Application: SSI 7485

I write regarding the proposed modification to M4-M5 Link, Mod 2 The Crescent overpass and changes to pedestrian infrastructure in North Annandale, Rozelle and Rozelle Bay Foreshore area.

Figure 4-1 Overview of the proposed modification

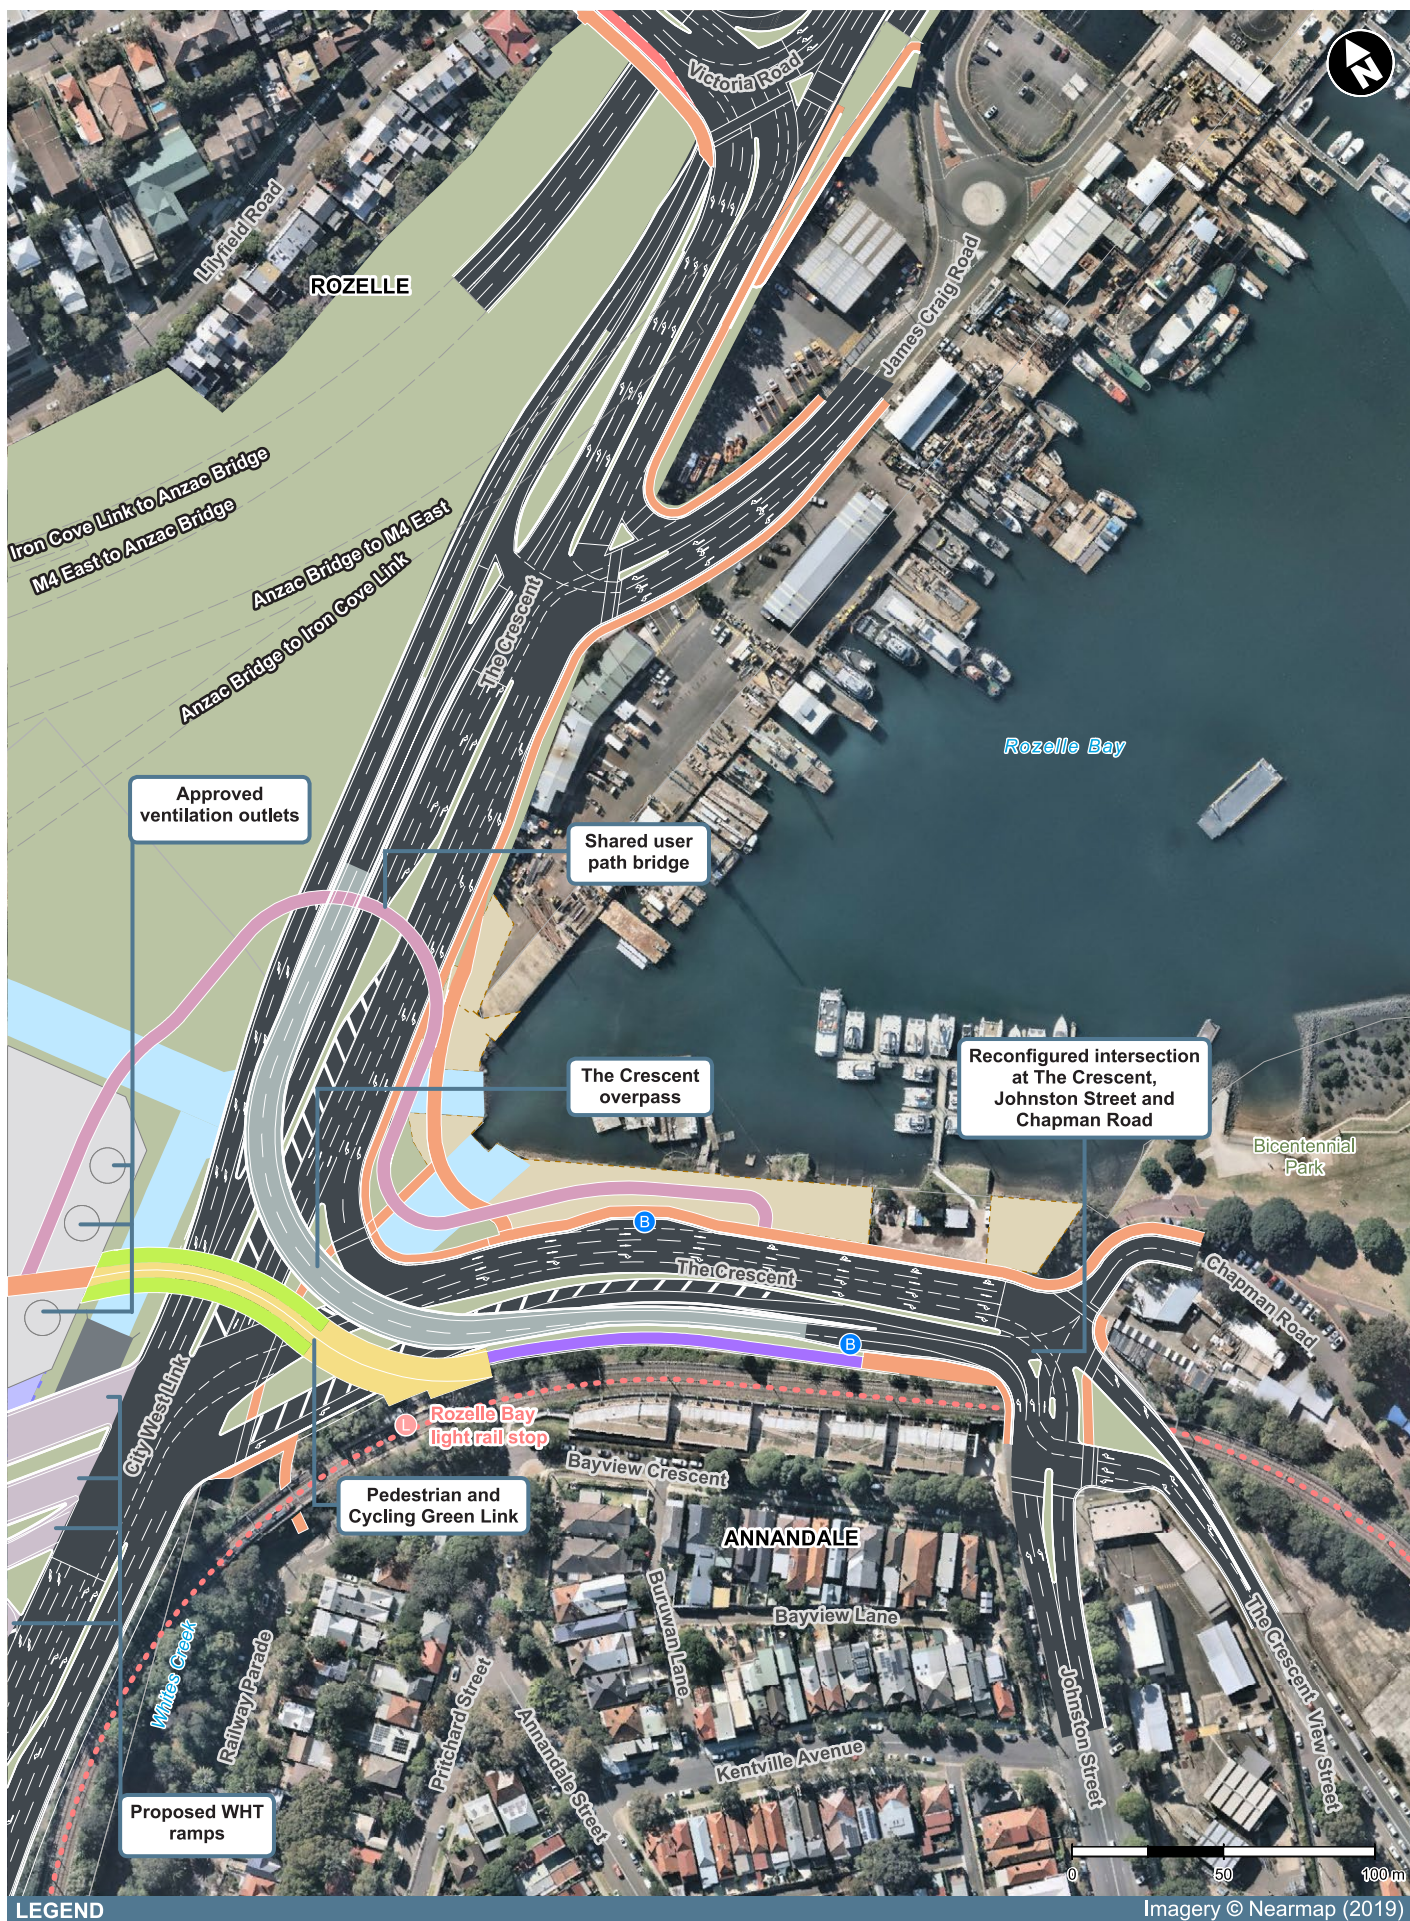
I request RMS work with the community to explore alternate design options to the proposed new car overpass design and the changed pedestrian and cyclist links. I am seeking the reinstatement of the safe, direct access from the approved EIS GreenLink to create a continuous green open space connection from the Rozelle Rail yards and Annandale to the foreshore. The GreenLink was more than just a walk way - it put people central to the design, maximising safety, and providing much needed accessible open space for the community now and into the future Bays Precinct design.

- The significantly reduced safety and increased risk for pedestrians and cyclists with removed access over The Crescent to Bicentennial Park and the increased traffic along Johnson Street.
- Being required to cross five sets of pedestrian lights at The Crescent as my option to reach the foreshore from Annandale or from Rozelle Bay light rail stop.
- Removal of direct active links to the foreshore, cutting the community off from the area and the proposed revitalisation of the entire Bays Precinct, including linking the Light Rail and Bus stops to a Ferry wharf and Metro station.
- Urban and landscape design that is being built before a finalised Masterplan for the area.
- Traffic changes that limit movements around the suburb and create further congestion in the local streets of Annandale, Forest Lodge, Glebe, Lilyfield and Rozelle with no planning to deal with these.

Figure 4-6 Elevation: Indicative view of Rozelle Rail Yards Pedestrian and Cycling Green Link

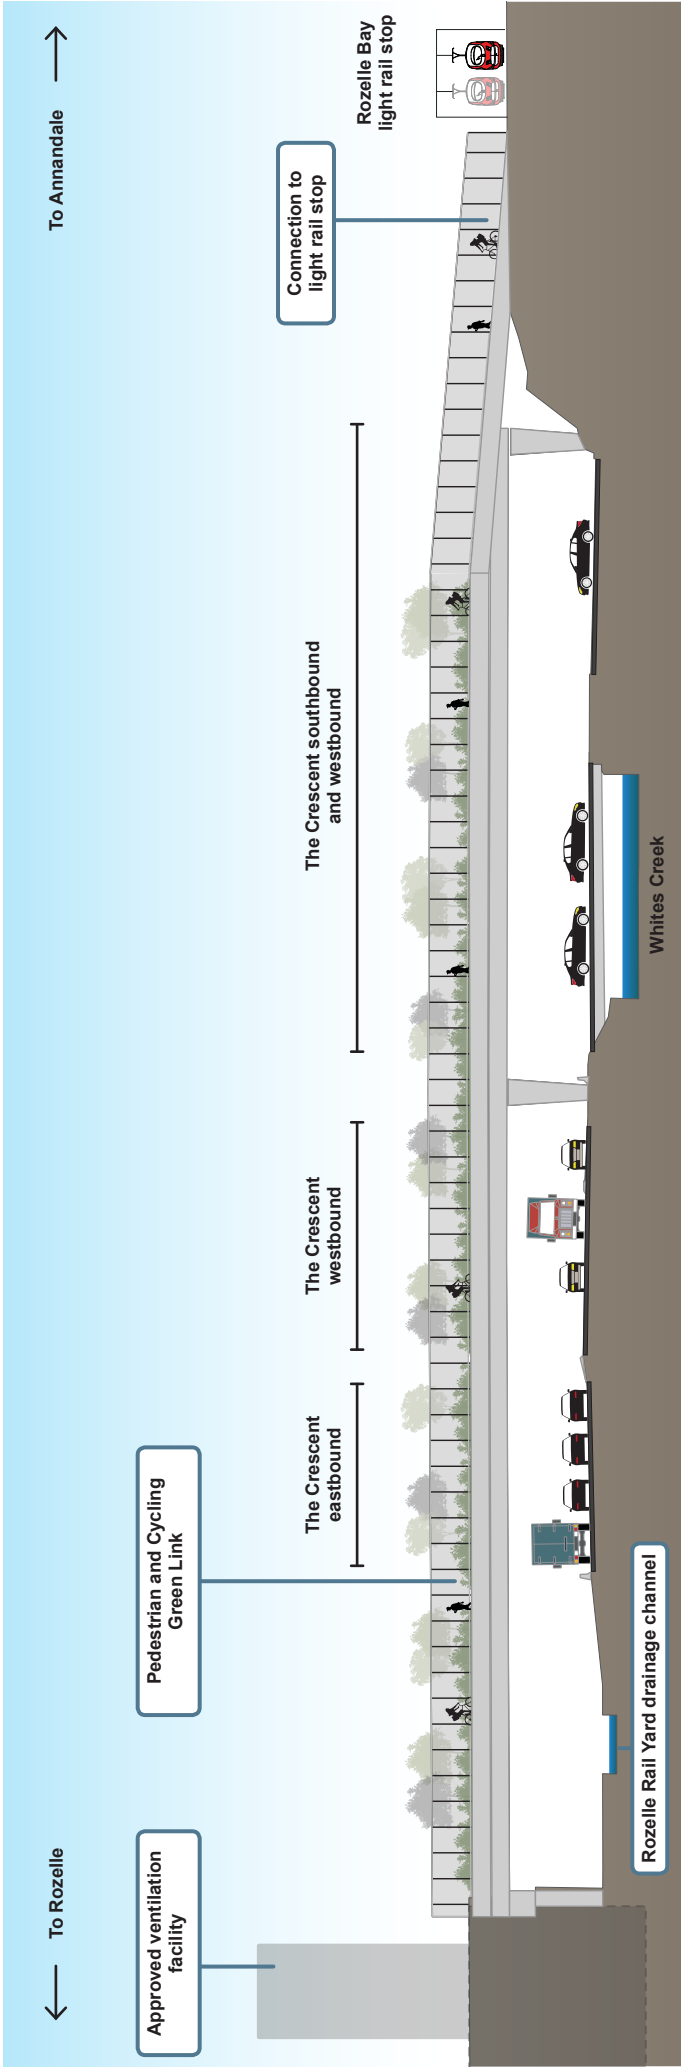
- Reinstate the GreenLink connecting communities and green open space from Rozelle to Bicentennial Park
- Relocate and design pedestrian and cyclist connections that are continuous, safe and direct.
- Design the modification infrastructure and active links in response to the character of the suburbs, the location of the foreshore and it's potential future development.
- Provide pedestrian and cyclist paths that maximise people safety and do not force them onto busier streets, unsafe concrete plazas and caged walkways.
- Integrate active and direct connections to all active transport - including the future Metro West and Foreshore Ferry Wharf
